Our Ref: PE/ARU13/12/A

Re: The Vinery, Poling, BN18 9PY.

Thank you for your correspondence of 05th June 2013, advising me of a proposed development at the above location, for which you seek advice from a crime prevention viewpoint.

CLIENT	CHECKED LRA
	DRAWN BH
DRAWING PROPOSED SITE PLAN	DATE NOVEMBER 2012
	SCALE 1:500/2500 @ A1 1:1000/5000 @ A3
	REVISION A
	NUMBER 0764-PA-010

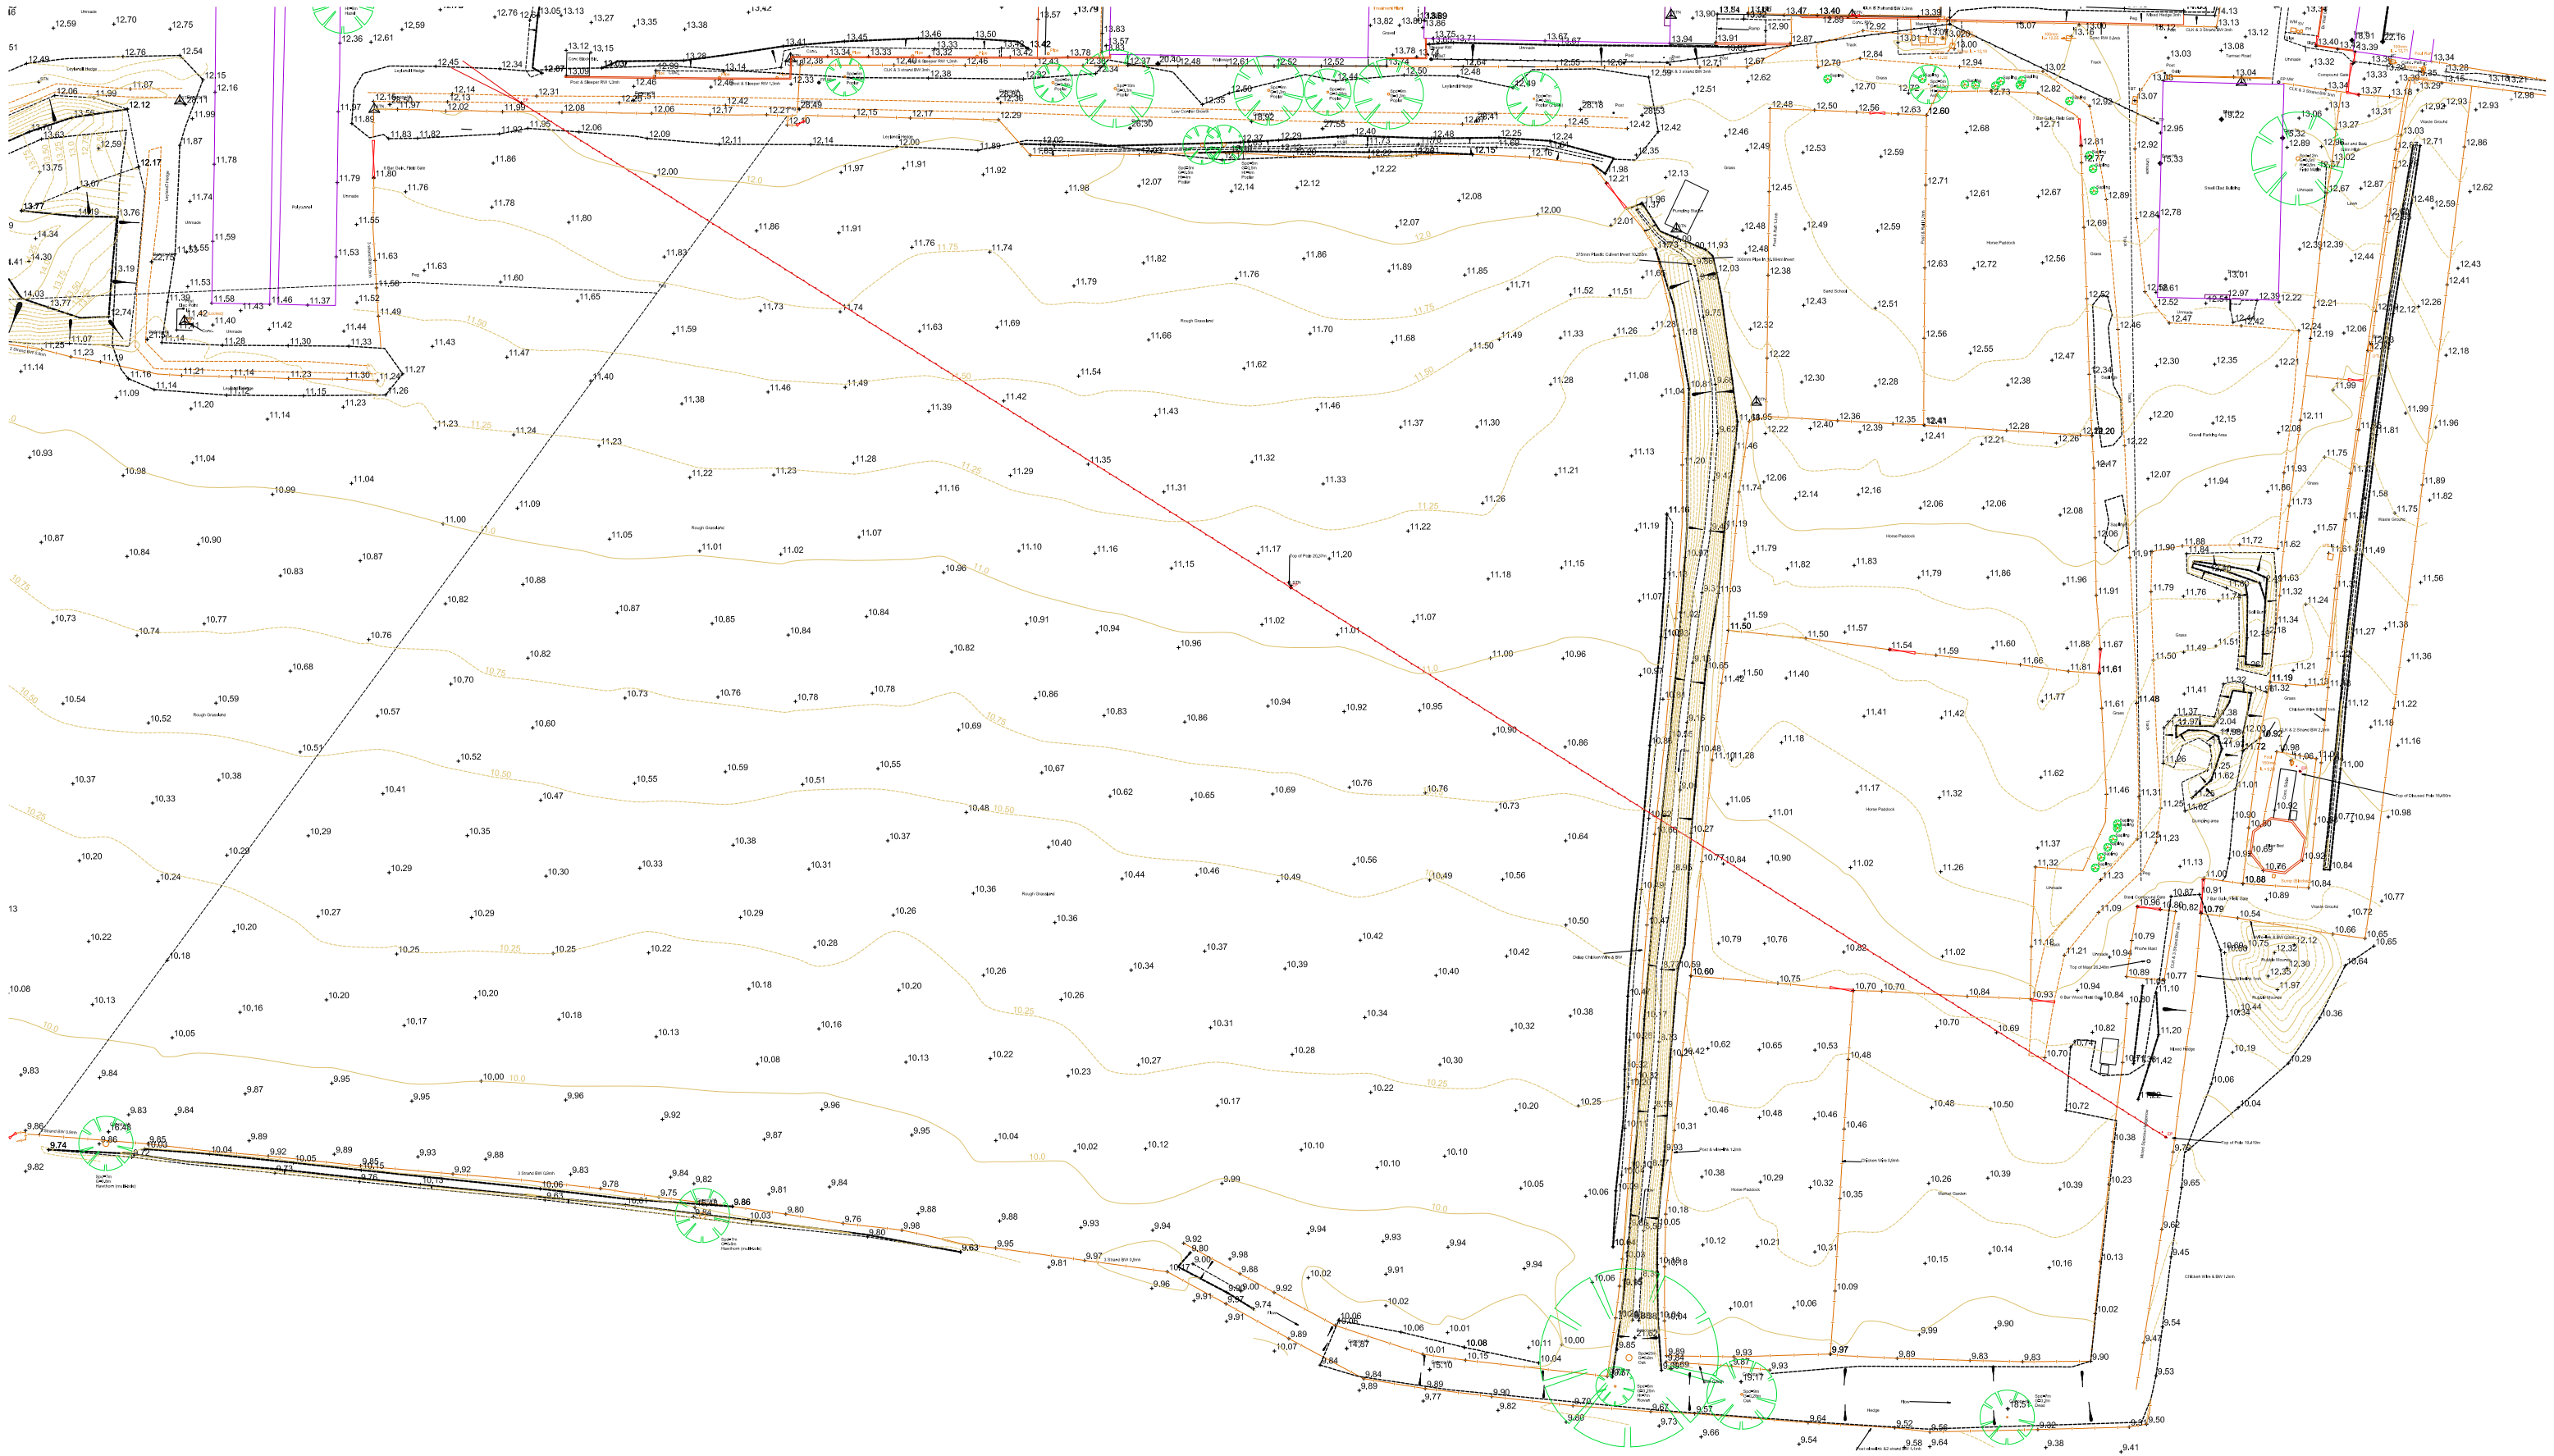
I was pleased to note from the site plan submitted that there is a proposed perimeter security fence with security gates within. I recommend that these security gates are controlled with an access control system that will allow authorised access to deliveries and staff. A remote facility should be available to allow visitors access on approval.
